From: Maria Tomalova <Maria.Tomalova@arun.gov.uk>
Sent: 29 May 2020 13:38
To: Planning.Responses <Planning.Responses@arun.gov.uk>
Subject: RE: Y/29/20/DOC - Former Reptune Garage, Main Road, Yapton

Subject: RE: Y/29/20/DOC - Former Reptune Garage, Main Road, Yapton

Comments in red below (I note the revised drawings are contained within the technical report);

Paul Cann
Principal Drainage Engineer
Engineering Services

PERMEABLE BLOCK PAVING CAR PARK DETAIL
(Scale 1:20)

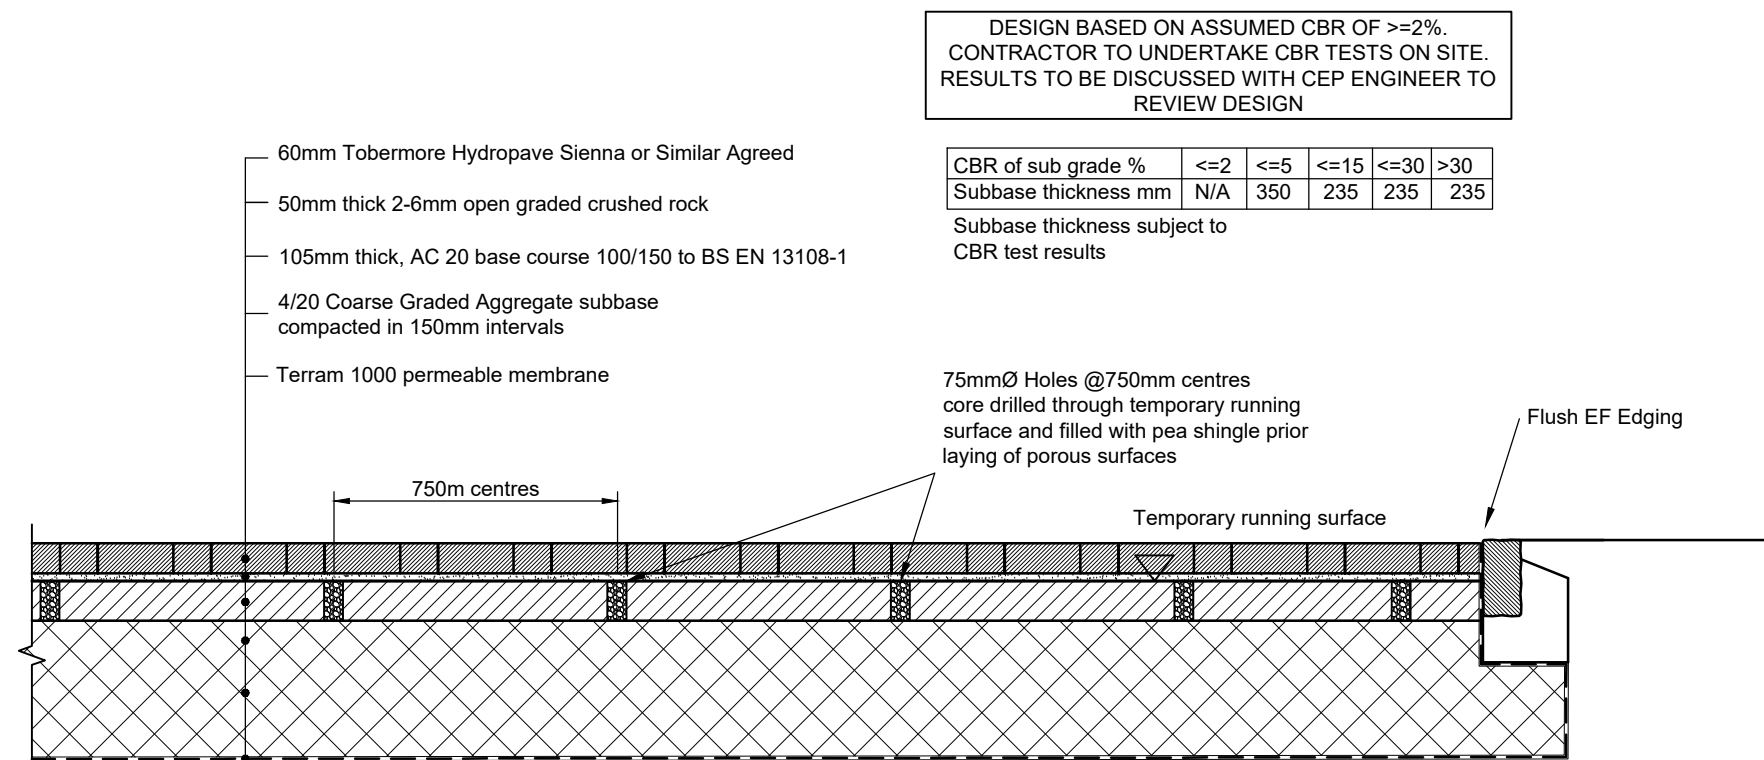
- 6) Added. ok
- 7) Added where required. ok
- 8) This is a design preference. We have not shown this as there no practical reason or benefit in doing so. The request would require laying asphalt directly onto the permeable membrane during the construction process. The contractor will need to ensure that no fines enter the sub base during the laying of the base course.

- 9) The subbase thickness is dependent on the CBR values and not on the subbase thickness as demonstrated within the supporting calculations and information shown on drawings. Subbase thickness is based on an assumed CBR of 2-5% requiring minimum 350mm of subbase, storage requirements for the infiltration system for a critical 1 in 100 plus 40% climate change storm is a 240mm depth of subbase. ok

- 10) Additional levels added and subbase thickness updated to reflect the assumed CBR. There is a significant slope on the permeable paving formation level, based upon the finished surface levels provided. The calculations will need to take account of this slope, to ensure that the 1 in 100 year event + 40% is contained within the structure. There is no parameters shown in the calculations to suggest that the slope has been accounted for.

CLIENT		Mr Pete Mountford	
PROJECT		Repture Yapton West Sussex	
TITLE		Proposed Layout Drainage Strategy Plan	
DRAWN	DATE	PROJECT NO.	
M Pacifico	Nov 2019	2326	
ENGINEER	CHECKED	DWG NO.	REV.
M Kempshall	SRM	101	B
SCALE	1:200 @ A3

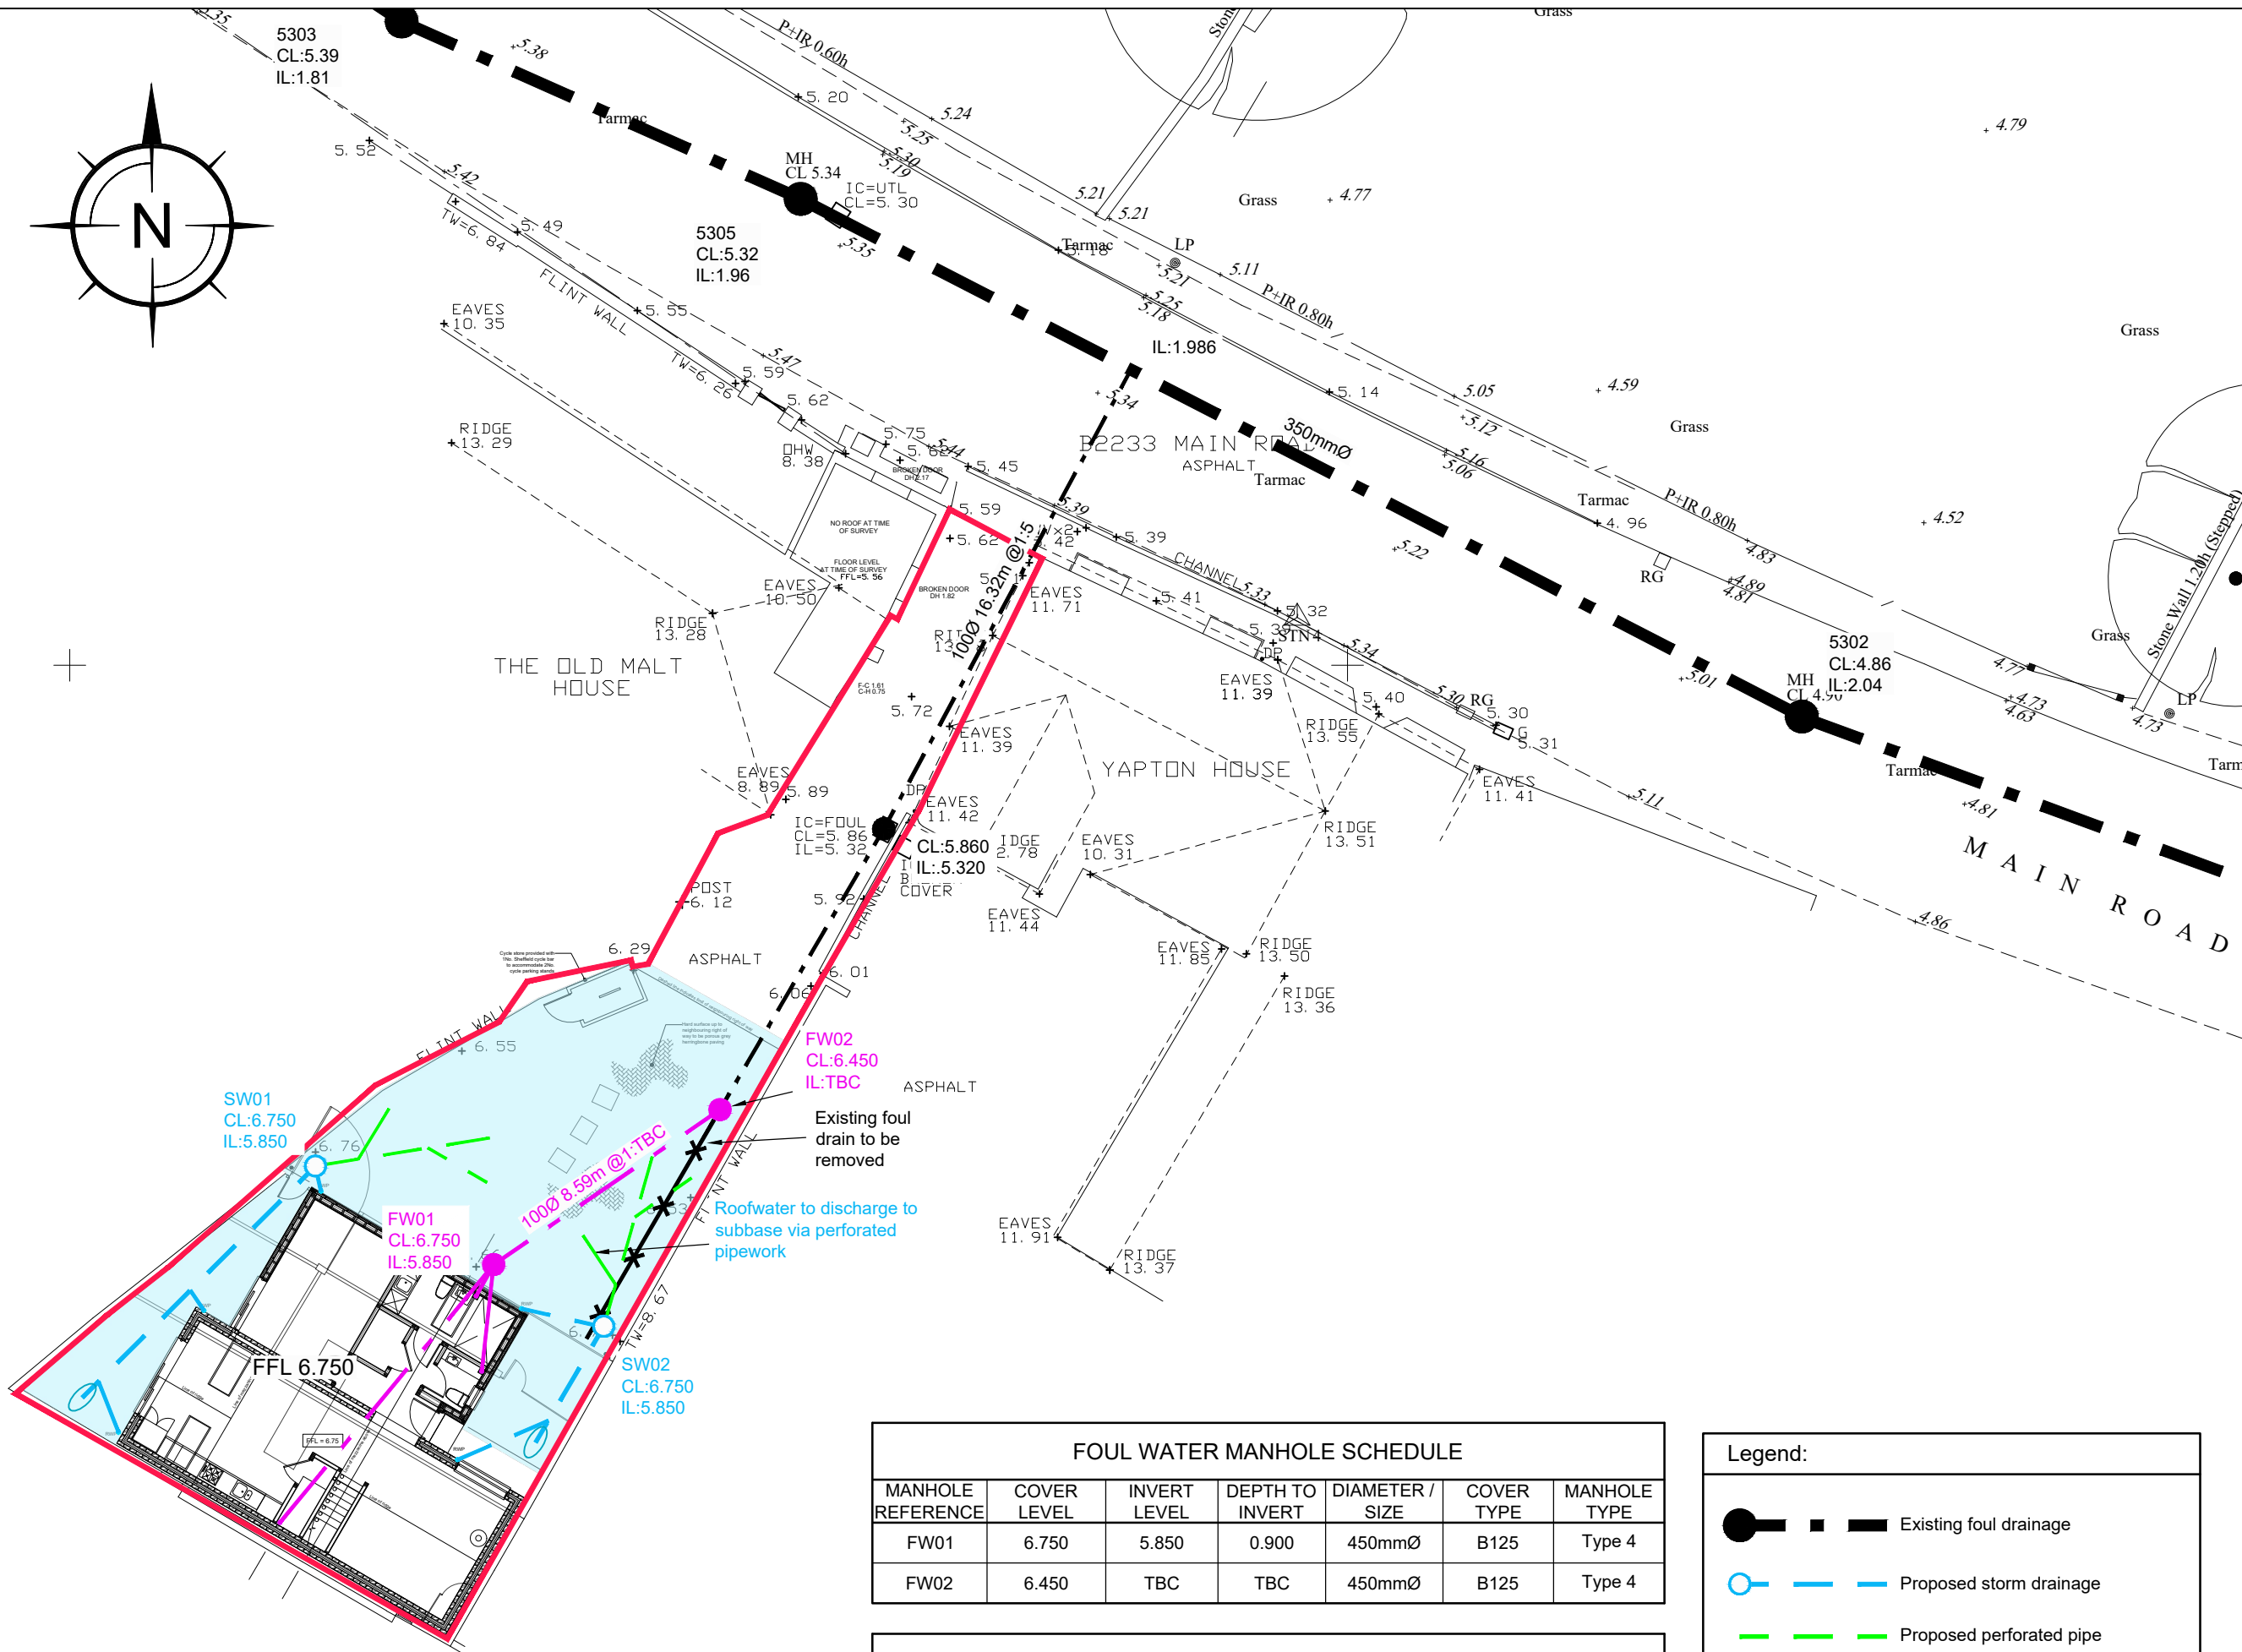
- 2) The extent of the proposed new paving is shown on the drawings which is reflected in the areas of the infiltration blanket within the supporting calculations. The drainage strategy plan, attached again for quick reference, shows no surface treatment changes to the Northern end of the site. The blue shaded area is the area subject to resurfacing. Noted

- 5) Added where not shown – The foul water pipe connecting proposed FW01 and FW02 will not be known until construction and the minimum fall has been stated. Specify pipe diameter and gradient between catchpits and diffuser units. Also indicate pipe invert level/finished paving level at connection to diffuser unit – to show that the pipe can be suitably connected based upon the proposed construction depth of the permeable paving.

CATCHPIT CHAMBER (Scale 1:20)

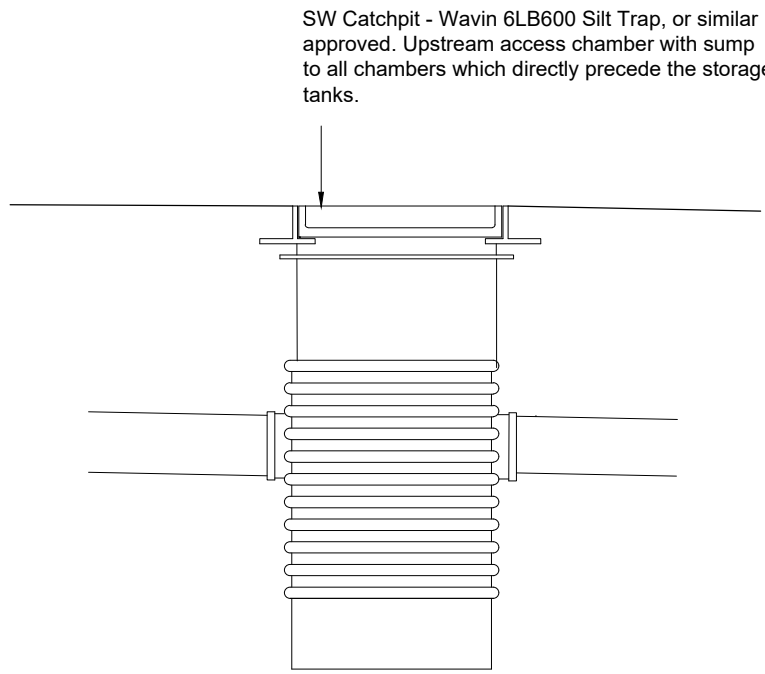
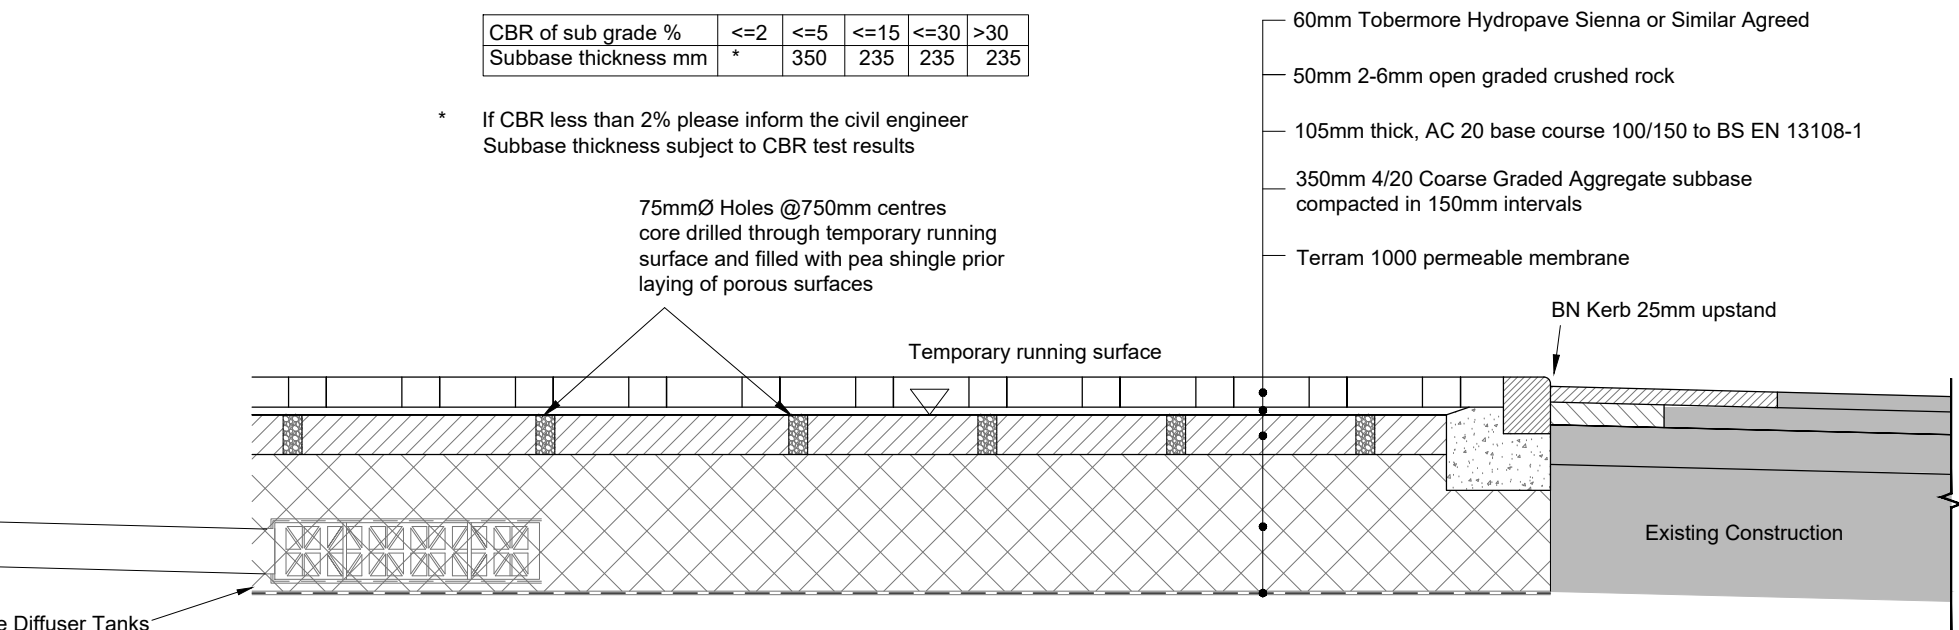
- 4) This is again a design preference. This is fundamental in ensuring that the risk of silt entering the diffuser unit is minimised, is good practice and provides a convenient chamber to enable silt removal. We have added silt traps upstream of diffusers in this instance, however diffuser units are only receiving roof water and any silt / sediment. Any loose sediments or fines are likely to be very low and unlikely to be significant enough to restrict performance of the diffuser units however we have determined in this case they are of benefit. It is surprising how much silt can be produced from a roof, especially when moss's etc become established on the tiles over time. Please add sump depth (min. 300mm) to construction detail.
